Item No. **Report of the Head of Planning, Transportation and Regeneration**

Address 27 EASTBURY ROAD NORTHWOOD

Development: Two storey front extension, part two storey part single storey rear extension, conversion of roof space to habitable use to include 3 x side dormers and 3 x roof lights and conversion of garage to habitable use

LBH Ref Nos: **75352/APP/2020/183**

PROPOSED GROUND FLOOR PLAN
Scale 1:100

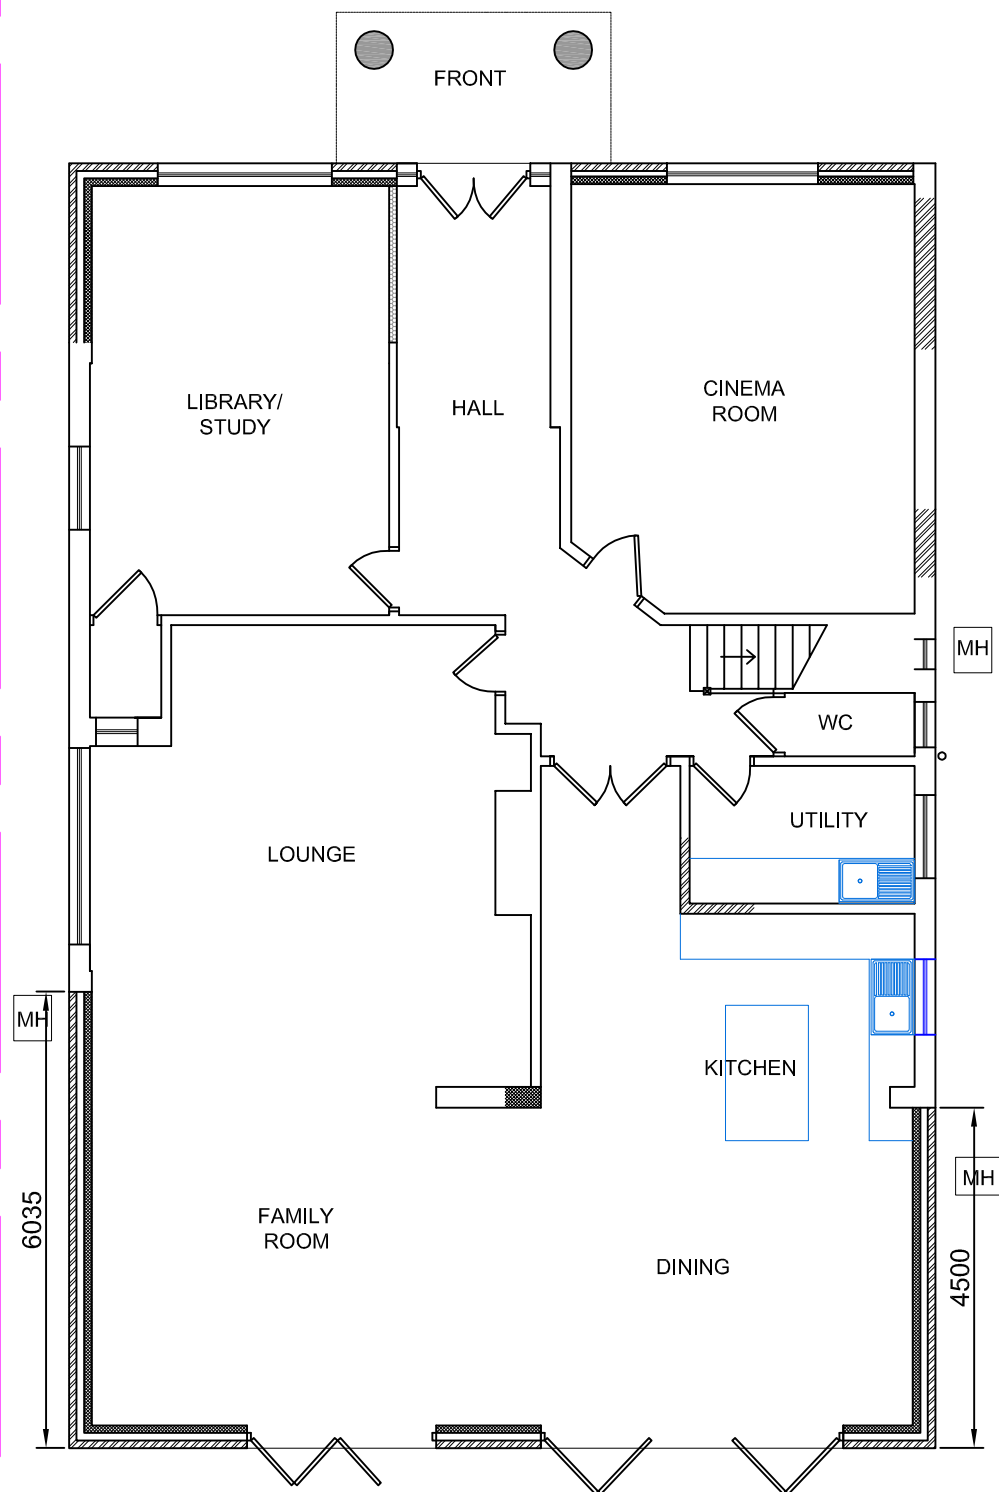
Although the ground floor extension is part 6.035 m deep this is due to it being an infill of an uneven back elevation with part being only 4.5 metres deep. The first floor is only 3 metres deep. Although the ground floor is deeper than that set out in Policy DMHD 1, there is only one neighbour, No. 25 which is protected by a strong mature hedge and no residential amenity issues arise in terms of loss of daylight, sunlight, overbearing issues or loss of privacy. In the event of approval new side windows could be conditioned to be obscure glazed and part non-opening. Rear facing windows form a normal relationship with neighbours.

From a Conservation view, on balance, it is disappointing that the rectangular nature of the ground floor projection would somewhat cut across the triangular form and this could be addressed through a further submission.

PROPOSED LOFT FLOOR PLAN
Scale 1:100

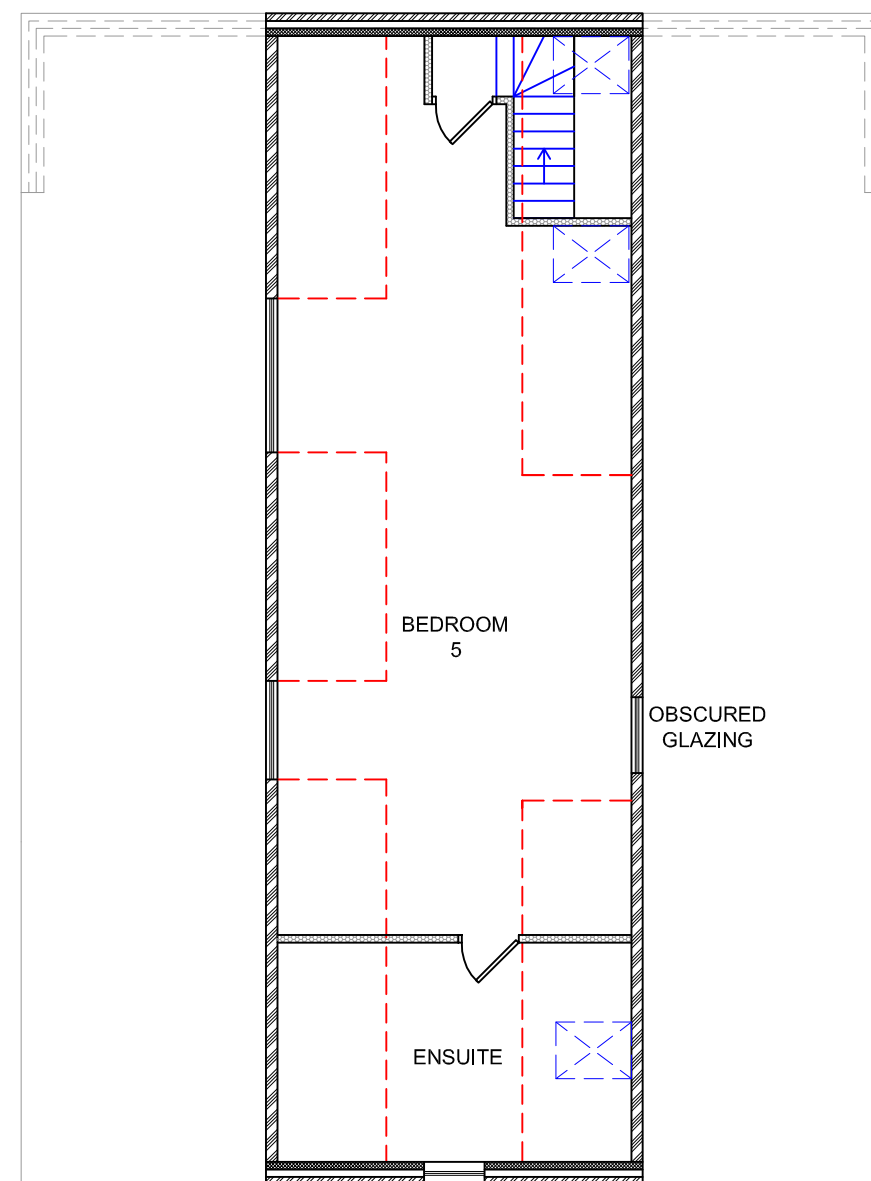
The proposed additional dormers along the flanking roof slopes are considered in principle unacceptable. It would essentially add further 'ears' to the building, disrupting its well-defined triangular built form which would be considered harmful to the character and appearance of the conservation area and street scene. The two tiered nature of the dormers and scale would fail to remain subservient cluttering the roof slope. In the event of an approval the side dormers could be conditioned to be obscure glazed with limited openings to avoid material loss of privacy.

PROPOSED SIDE ELEVATION
Scale 1:100

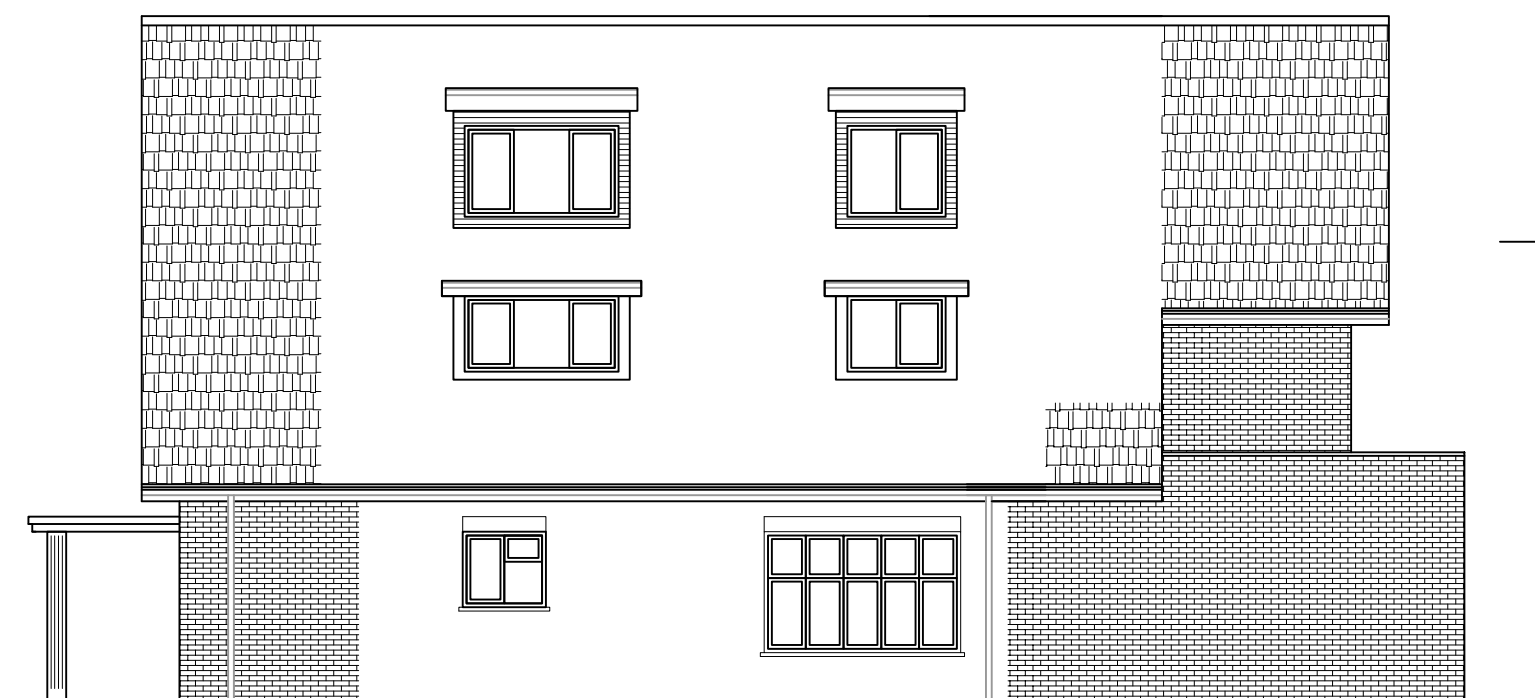
The proposed additional dormers would disrupt the well-defined triangular built form of the roof and the two tiered nature of the dormers and scale would fail to remain subservient cluttering the roof slope. As such the proposal would fail to harmonise with the character, proportions and architectural composition of the original dwelling and would have a detrimental impact on the appearance, character and visual amenities of the street scene and the wider designated Conservation area which it would fail to preserve or enhance. As such, the proposal would be contrary to Policies BE1 and HE1 of the Hillingdon Local Plan: Part One - Strategic Policies (November 2012) and Policies DMHB 4 and DMHD 1 of the Local Plan: Part 2 - Development Management Policies (2020).

PROPOSED FRONT ELEVATION
Scale 1:100

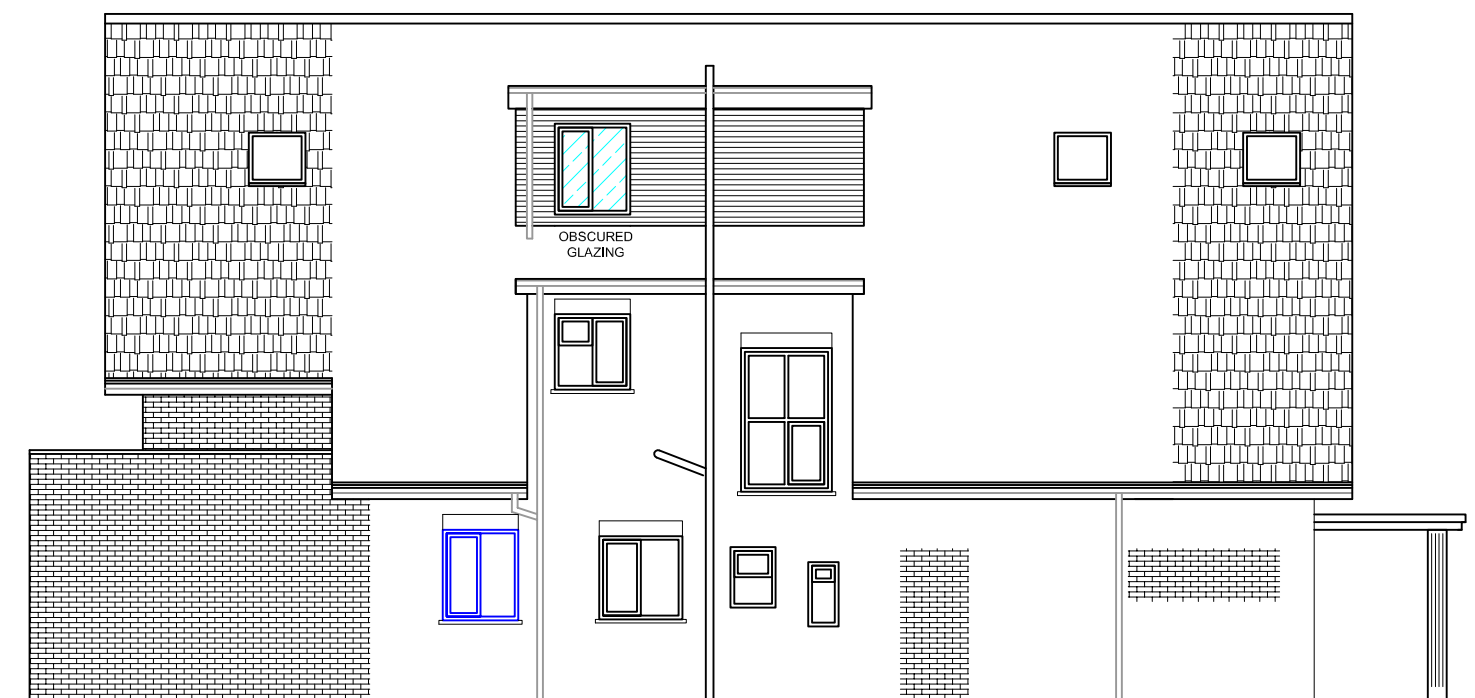
The proposed two storey front extension would result in the property projecting further forward and closer to the main road. There are significant concerns that a full height front extension is likely to have a significant impact on the conservation area. It is recognised to be an attempt to ensure the appearance of the gable end is not too different however the white banding over the converted garage and double door entrance would not be considered appropriate. Furthermore the proposed window to replace the existing garage door would fail to relate to the proportionate and arrangement of the existing windows and it is expected that it matches.

The double door entrance would result in detracting feature to the front elevation.

The proposed two storey front extension would result in the property projecting further forward and closer to the main road and would dominate the dwelling. As such the proposal would fail to harmonise with the character, proportions and architectural composition of the original dwelling and would have a detrimental impact on the appearance, character and visual amenities of the street scene and the wider designated Conservation area which it would fail to preserve or enhance. As such, the proposal would be contrary to Policies BE1 and HE1 of the Hillingdon Local Plan: Part One - Strategic Policies (November 2012) and Policies DMHB 4 and DMHD 1 of the Local Plan: Part 2 - Development Management Policies (2020).
